Your Ref: Inet 000011263
Our Ref: AW/178/11/
Please ask for:
Mrs J Chapman

Removal of conservatory, new front extension and porch, removal of 1 garage
(amendments to approval AW/323/07/)
15 Kingsway Aldwick

Block plan

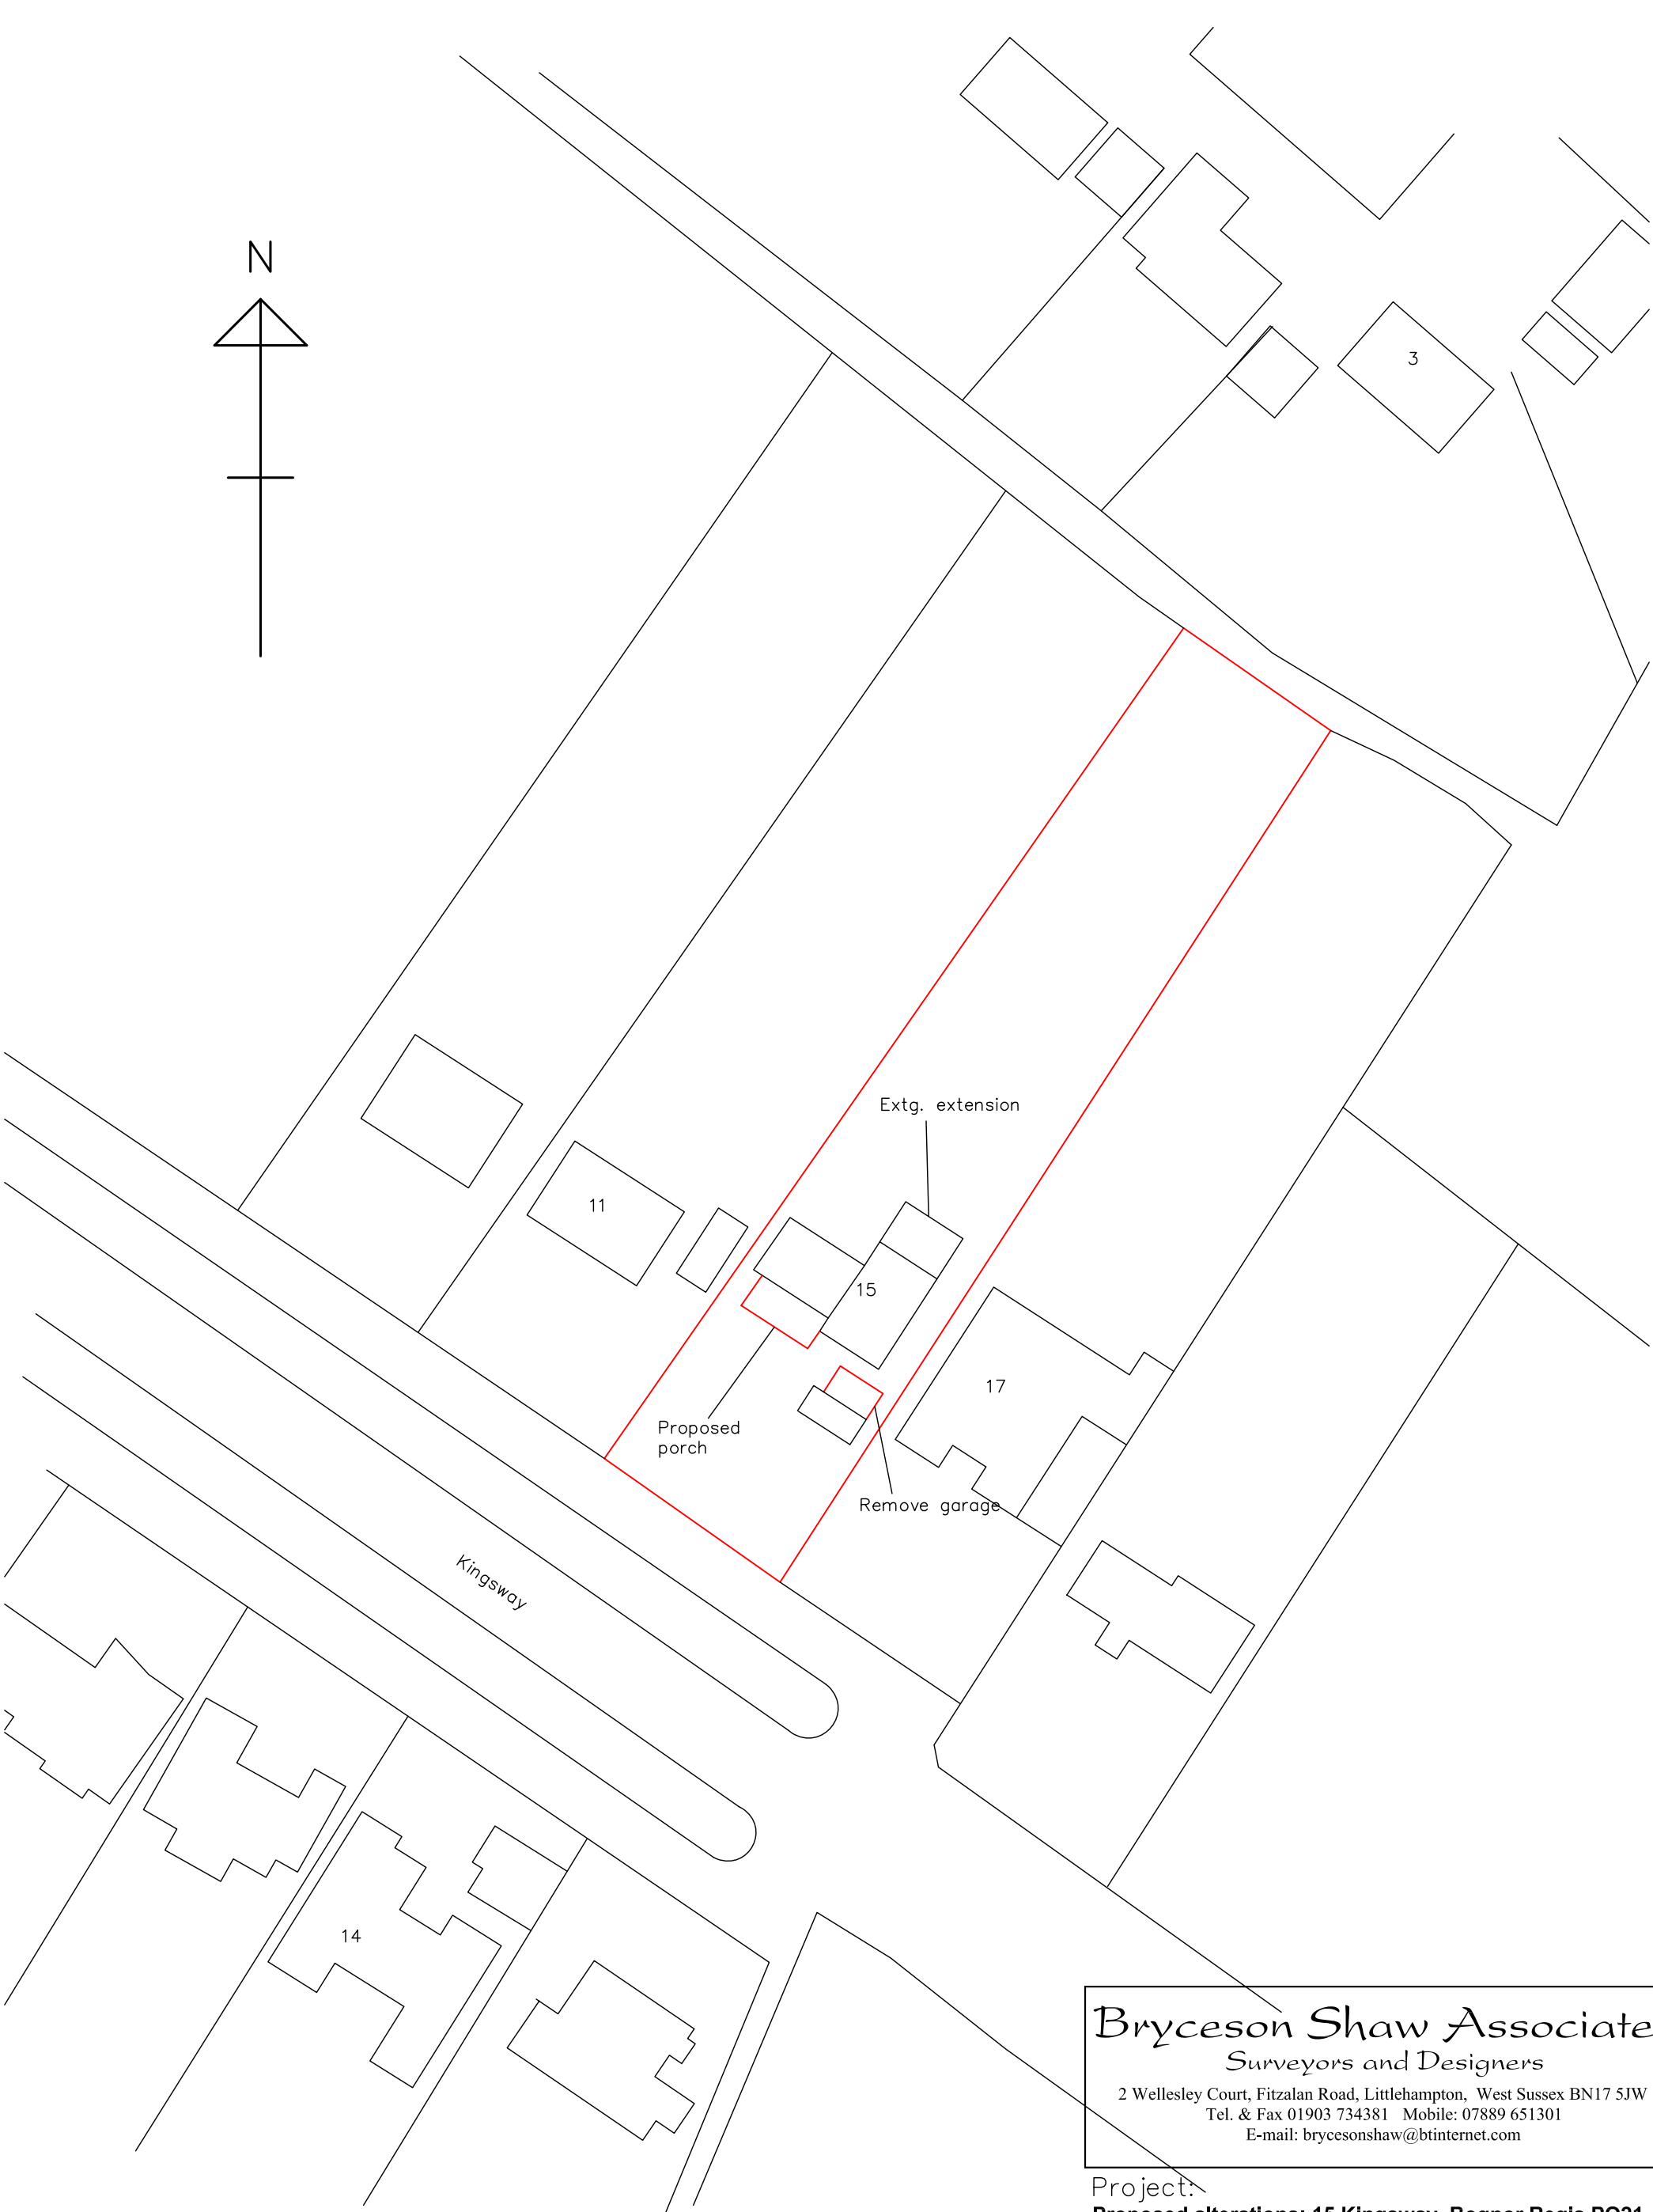
I notice there are no proposals within this application for renewing the driveway following what are substantive works to the house.□

Considering the requirements of the Craigweil House Conservation Area, specially the Article 4 provisions, I consider there must be reference to any alteration to the front hardstanding to the property.□
